Ref: Plan Item Analysis  
Pole Barn  
79 Vanstore Dr.  
Fuquay-Varina, NC  
Project No. 20-224

Plans for the above referenced site were reviewed on September 14, 2020 for the following items:

UP TO 50' TRUSS ELEVATION
 SCALE 1/4" = 1'

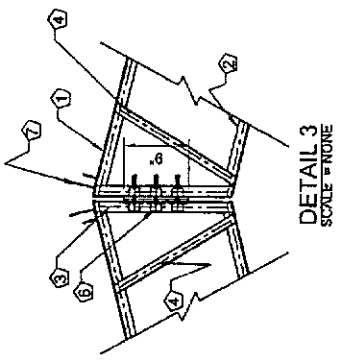
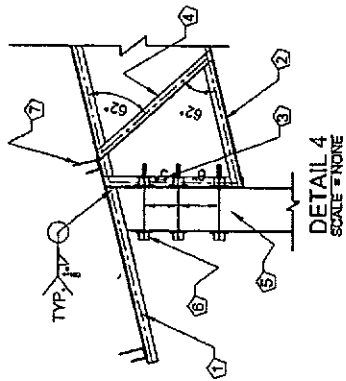
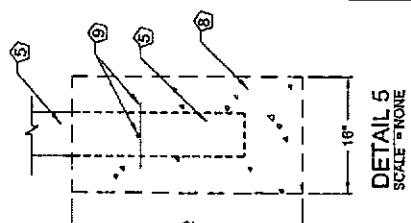
1. Owner/builder would like to use alternate anchor for posts.

1. The referenced project is a pole barn kit with plans and materials provided by a building supply company. The plans specify that the support posts for the structure be anchored in concrete footings. The owner would like to use wet set SWP66 anchor brackets manufactured by Sturdi-Wall in lieu of the plan specified embedded posts. The Sturdi-Wall brackets are adequate to resist all imposed design forces and are an acceptable alternate to the plan specifications. Note the plan specified footing sizes are adequate for the bracket installation.
